**KIRKLEES METROPOLITAN COUNCIL
INVESTMENT & REGENERATION SERVICE**

DELEGATED DECISION TO DETERMINE PLANNING APPLICATIONS

Reference No:	2024/62/92250/W
Site Address:	9, Carr Mount, Kirkheaton, Huddersfield, HD5 0PD
Description:	Erection of extensions to dwelling and detached garage/store
Recommending Officer:	Joanna Rednall

DECISION - REFUSED

Drawing Title
PROPOSED
FLOOR PLANS

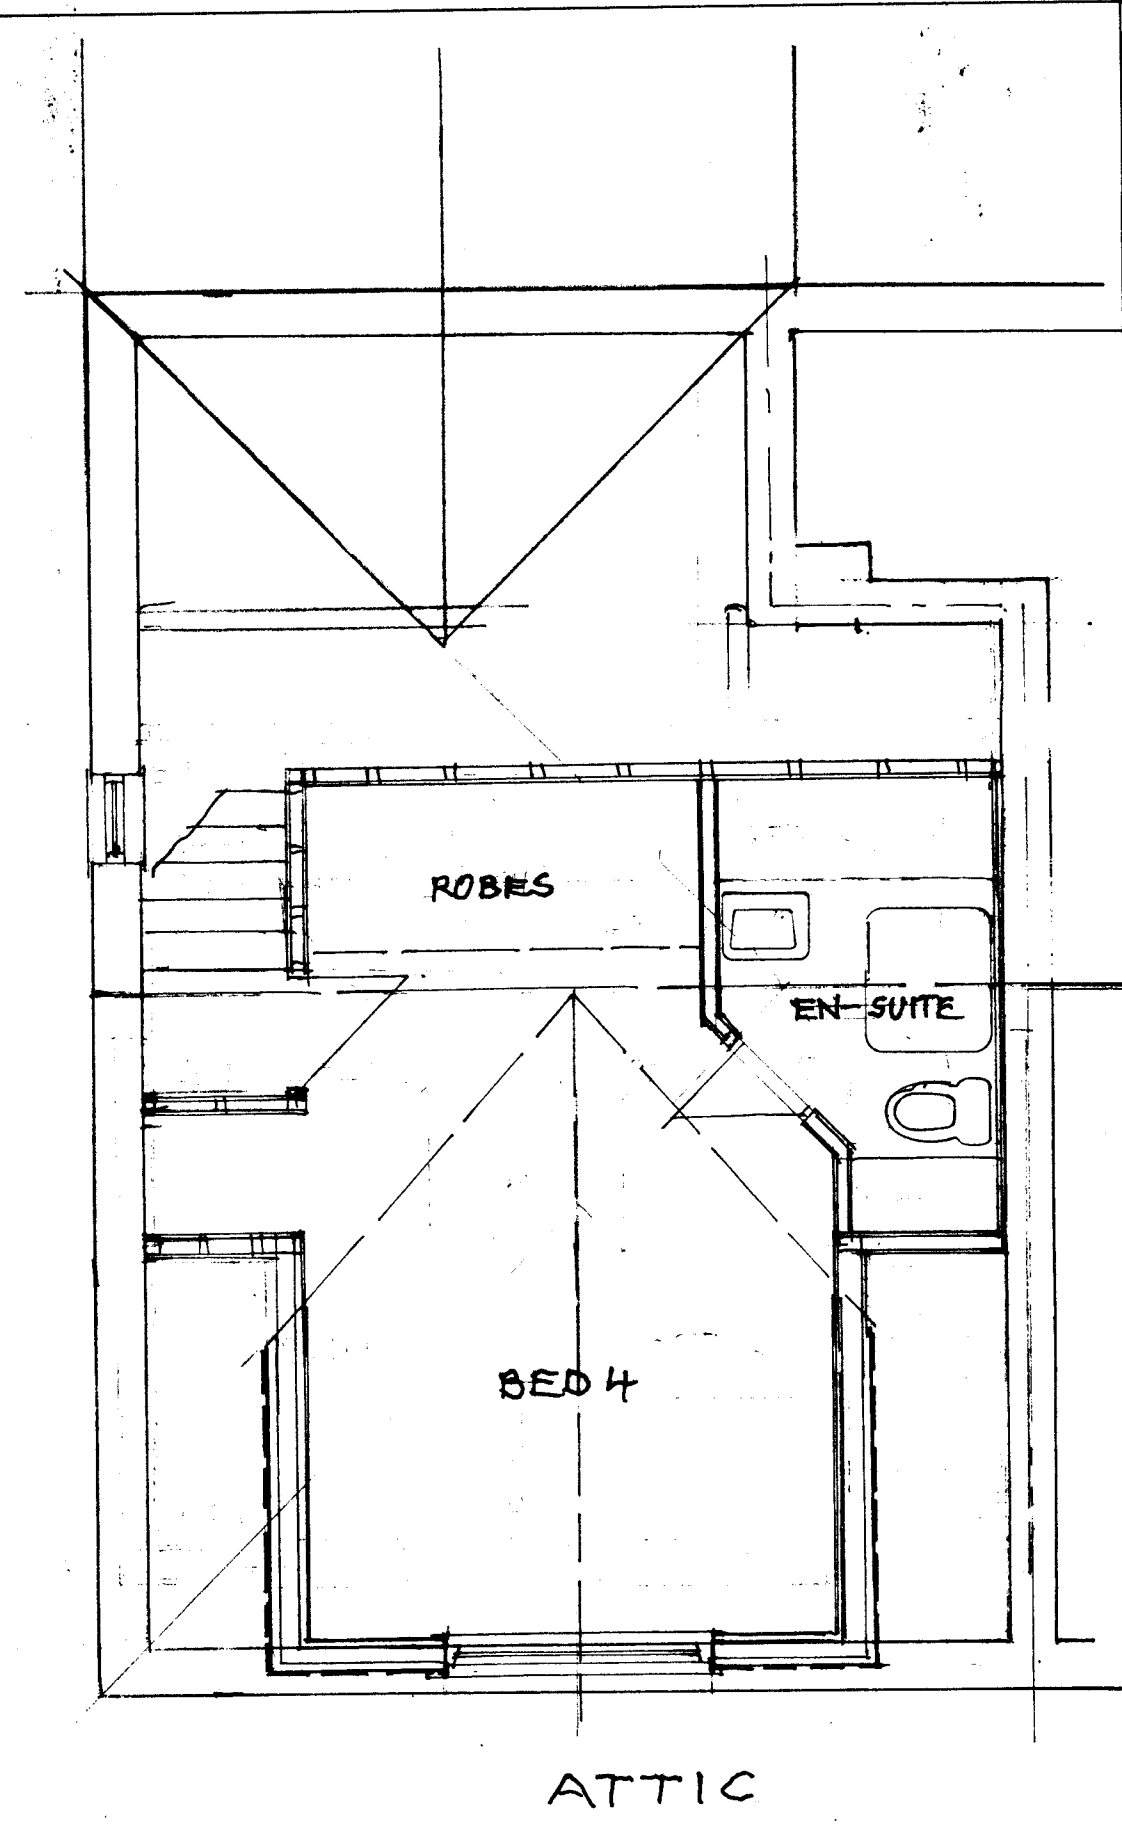
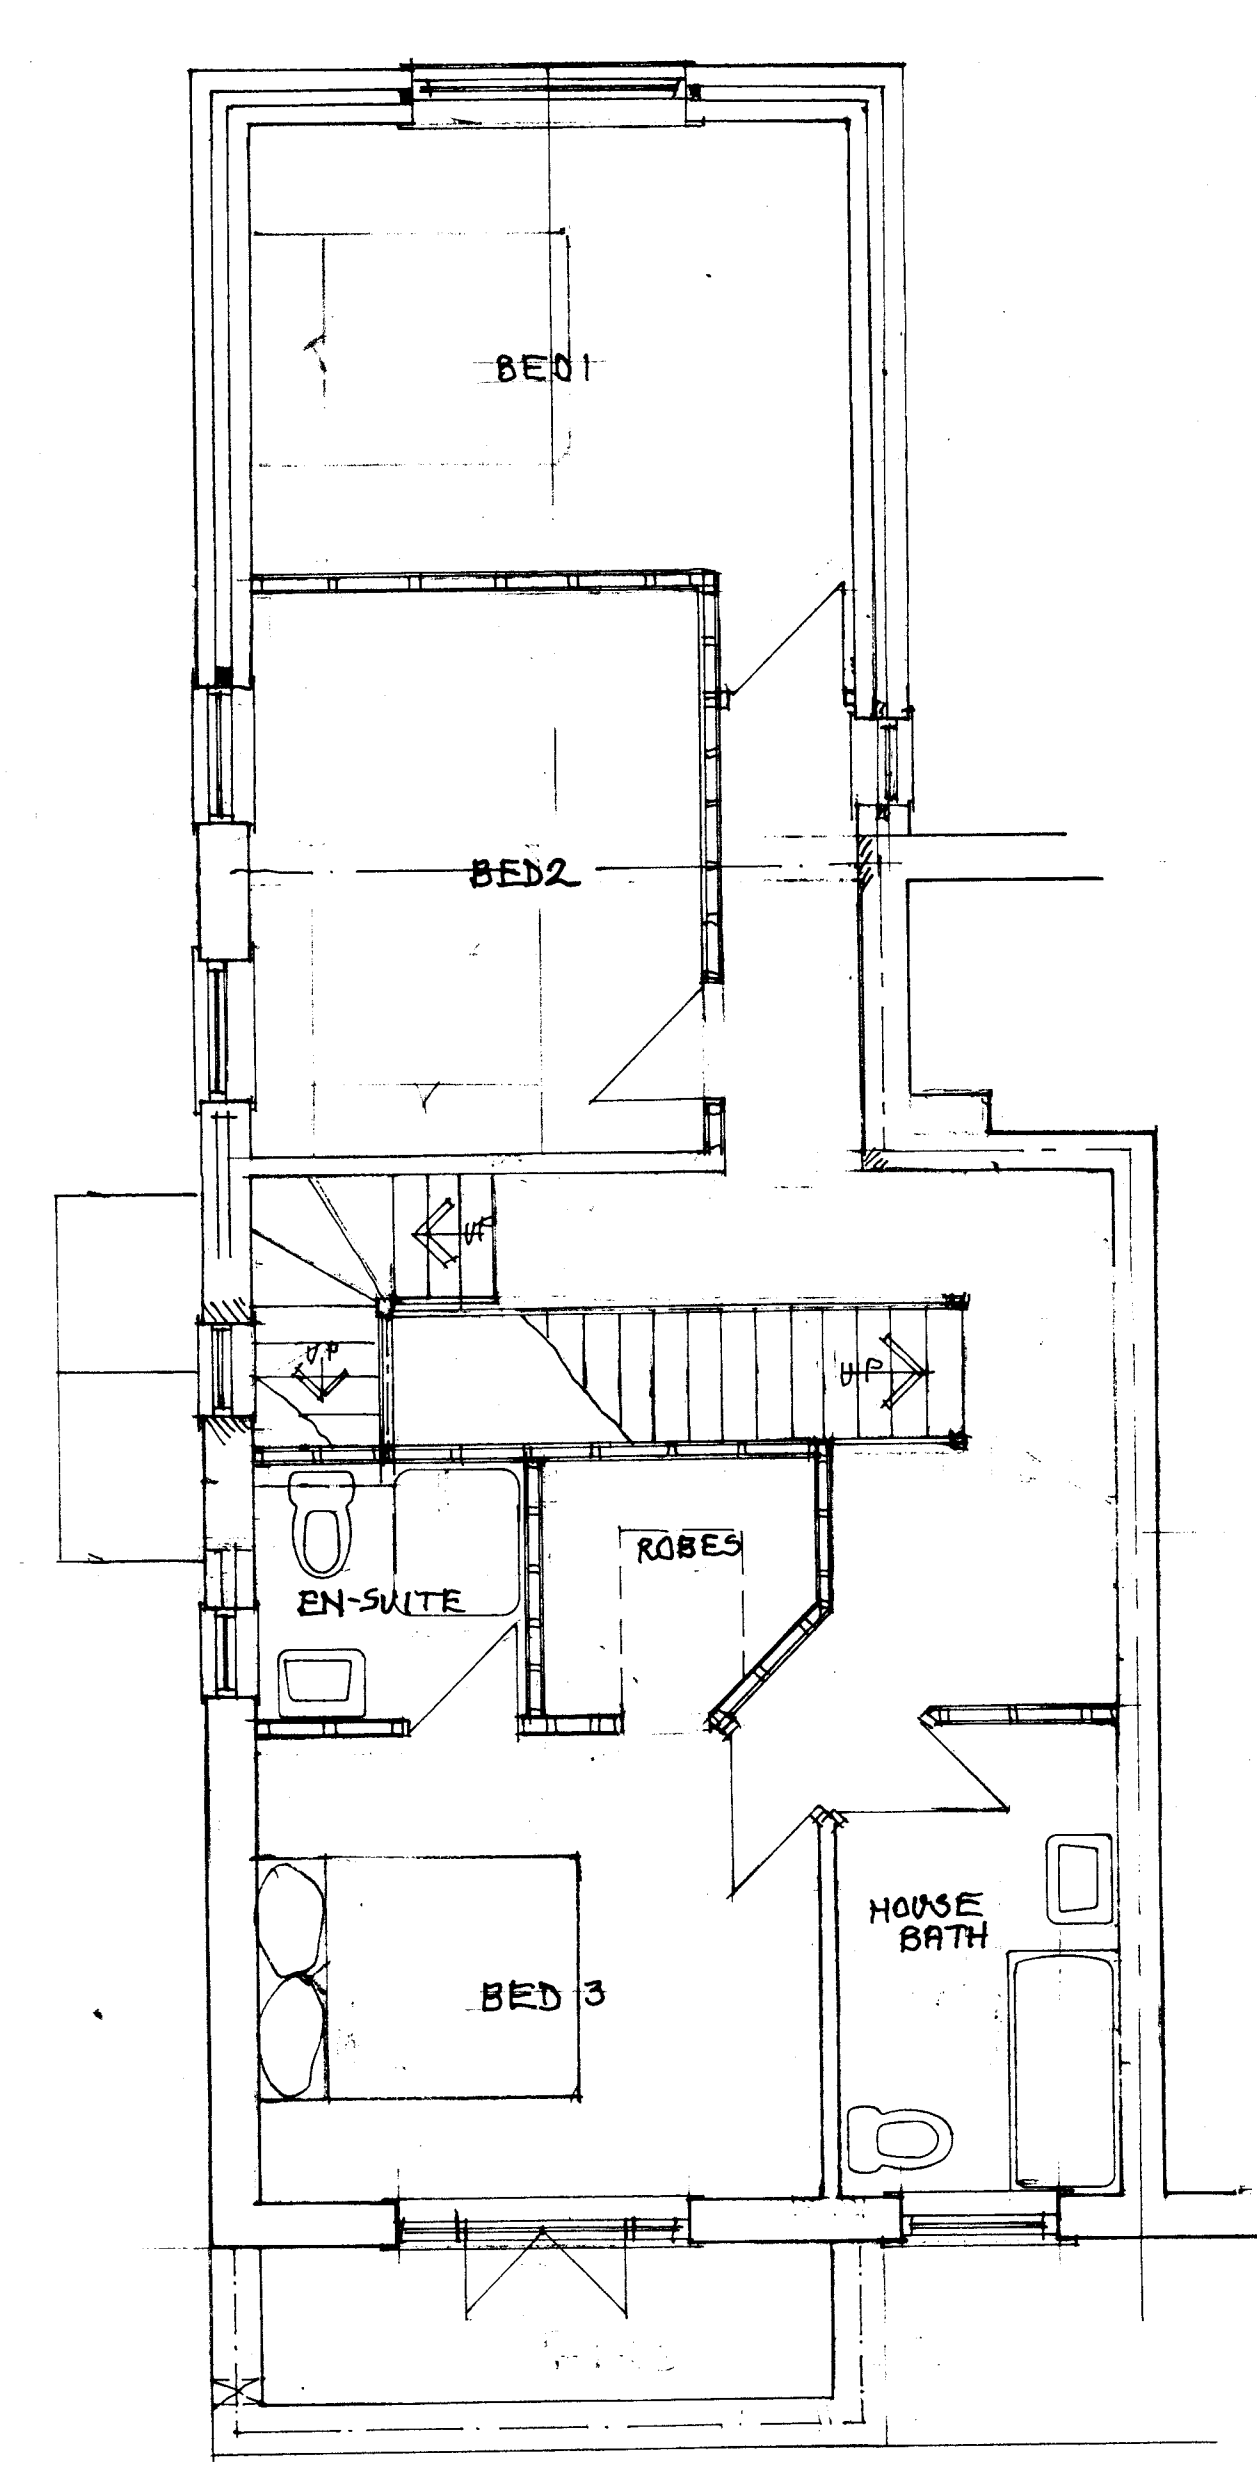
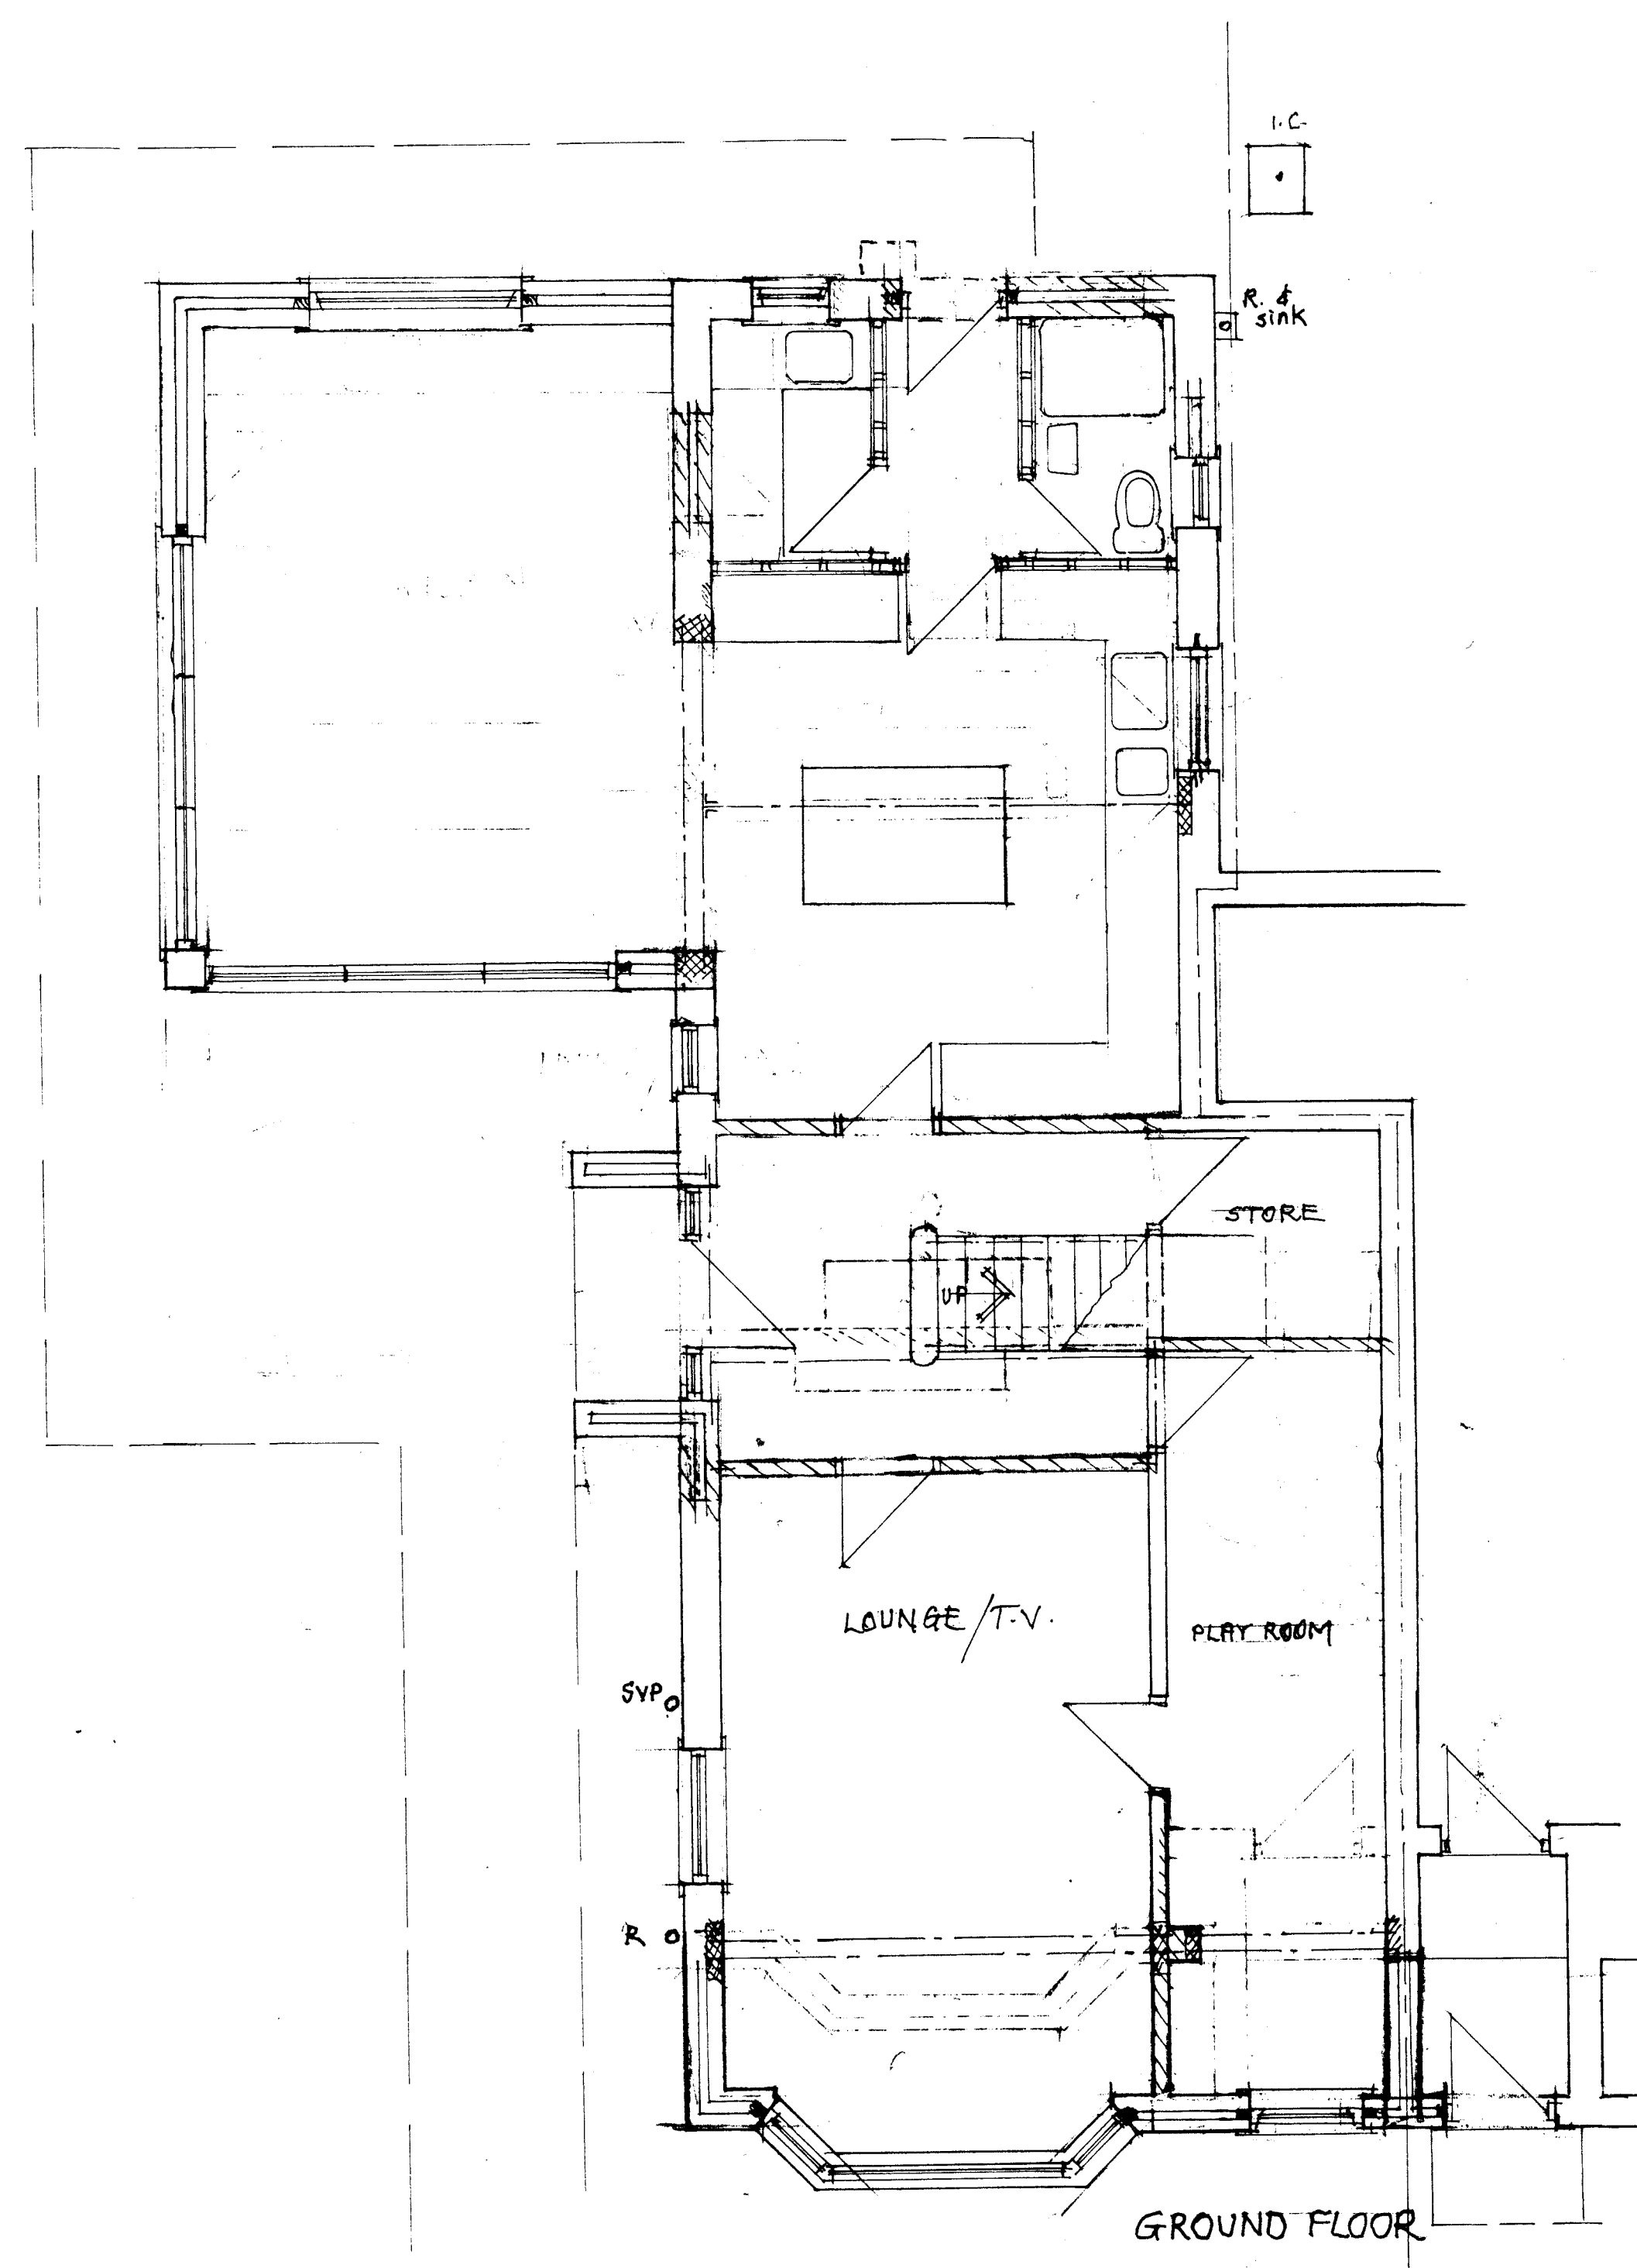
The first-floor extension is located to the rear of the property and would be constructed above the existing single storey rear projection. The extension would follow the outrigger of the first floor, increasing the total eave height to 5m and total ridge height to 6.7m. The first-floor extension would appear visually smaller in relation to the original house. This is because the ridge of the extension is appropriately set down from the ridge of the host property with its matching eaves to the host's own. The gable front feature appears subservient to the host and would reflect the design of the proposed roof. The materials and fenestration details would be in keeping with the host property, and the extension retains a gap of at least 1 metre to the boundaries of the site. Whilst this individual extension is of a scale and design relative to its site, this does not overcome the fundamental objections to the principle of development on this site. It is therefore considered that the cumulative impact of the first-floor extension would create a visually unacceptable impact, contrary to Policy LP24 and LP57 of the Kirklees Local Plan.

The dormer in this case is of a significant size and height that would dominate the front roof plane of the host property. The dormer is not set below the ridgeline of the existing property with only a small area of roof retained to the sides and below. The roof of the existing property would be increased in volume to form a gable design. This would unbalance the appearance of the semi-detached property and would create a cluttered and asymmetrical appearance with the addition of the front dormer. There are no existing dormer windows on neighbouring properties, and the windows on the dormer are not aligned with existing openings on the front elevation of the application property. It is therefore considered that the cumulative impact of the front dormer, hip to gable roof, front balcony, and additional extensions above would cause significant harm to the visual amenity of the original property and would form disproportionate additions and would be detrimental to the character of the Green Belt setting.

8, Carr Mount adjoins the application property to the east. The element of the proposal that would have the most impact on this neighbour is the first-floor rear extension. The first-floor extension projects 5m from the rear elevation of No.8 with one window inserted to the east-facing elevation. The additional window would serve a hallway (non-habitable) with an additional ground floor window proposed to serve a bathroom (non-habitable). These are not considered to cause detrimental harm to be overlooking the windows/ amenity space at No.8 as the main amenity space appears to be located to the front.

The first-floor extension, at a maximum height of approximately 6.7m is considered to have a significant impact upon overbearing/ loss of light currently received at No.9. Key design principle 5 of the Council's SPD relates to the 45-degree line, and although the neighbouring windows are not shown on the plan, given the proximity of the extension to this neighbour, it can be concluded the 45 degree line from the closest windows at No.8 would infringe upon the proposed extension. This would result in an undue overshadowing/overbearing impact and would significantly reduce the outlook of No.9.

The first-floor rear extension is therefore considered to significantly reduce the outlook and have an overbearing and oppressive effect on the windows serving this dwelling, contrary to Principles 3, 4, 5 and 6 of the adopted House Extensions and Alterations SPD, Policy LP24 of the Kirklees Local Plan and advice within Chapter 12 of the National Planning Policy Framework.
